Rezoning Transportation Analysis

Petition Number: 2021-125

Date	Description
09-17-2021	First Review (WLB)
11-22-2021	Second Review (AO)

# RZ-1.0

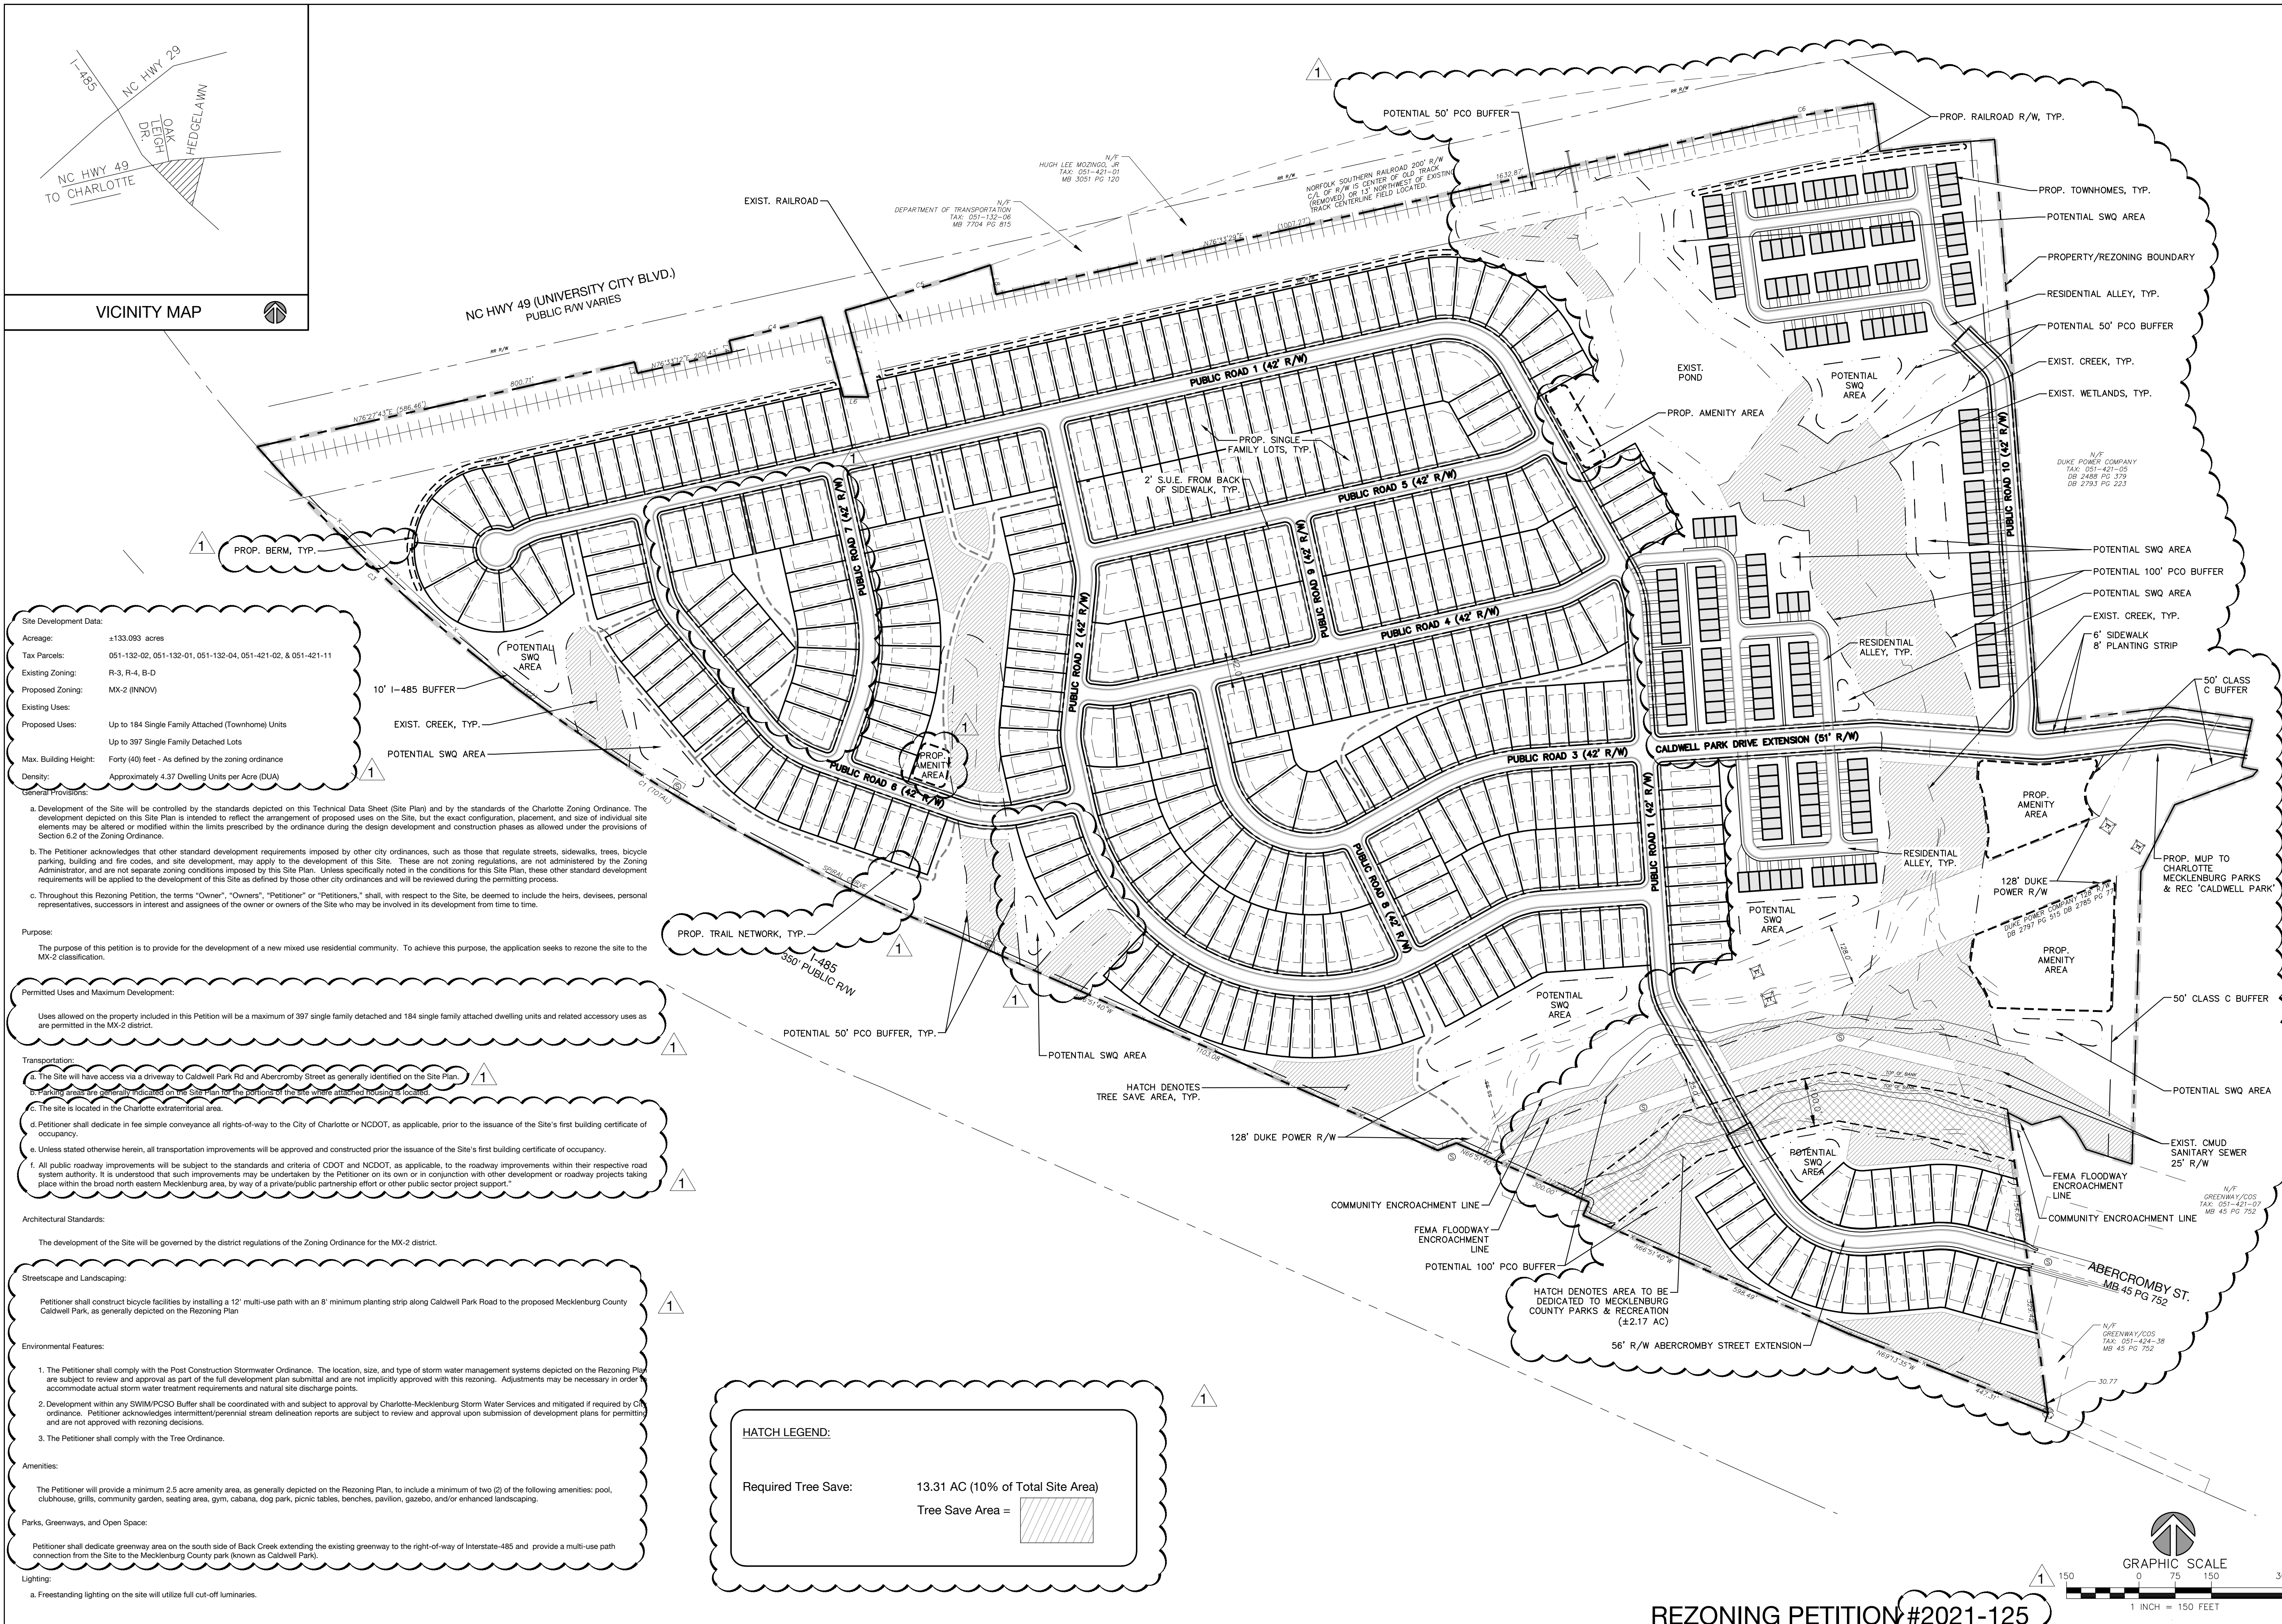
Outstanding Comment from 9-17-21: Label and dimension the future curb and gutter from the centerline for each road on the site plan.

3. **Outstanding Comment from 9-17-21:** Site plan and conditional note(s) revisions are needed to commit to construct bicycle facilities by installing a 12' multi-use path with an 8' minimum planting strip on the site side of University City Boulevard from Harris Houston Road signal east to eastern property line, and the north side of University City Boulevard from Harris Houston Road, east to Hedgelawn Drive and west to Halton Park Drive. in accordance with the City Charlotte BIKES Policy. Site plan should depict, label and dimension proposed and existing transportation facilities on both sides of University Blvd, including labeled intersecting streets.

New Comment 11-22-21: Show existing University City Blvd and all proposed improvements along University City Blvd on site plan.

- Outstanding Comment from 9-17-21:** Site plan and conditional note(s) revisions are needed to commit to installing bike and pedestrian crossing to include ADA compliant Curb ramps and pedestrian signals on both sides of the University City Boulevard at Harris Houston Road intersection in accordance with the City Charlotte BIKES and Charlotte WALKS Plans. Petitioner to coordinate with the University City Blvd/Harris Houston signal Project to ensure that the Z-crossing and proposed ADA facilities will accommodate the 12-foot multi-use path.
- Outstanding Comment from 9-17-21:** Add conditional note(s) committing to extend Abercromby Street to proposed Public Road 2 per the Subdivision Ordinance.
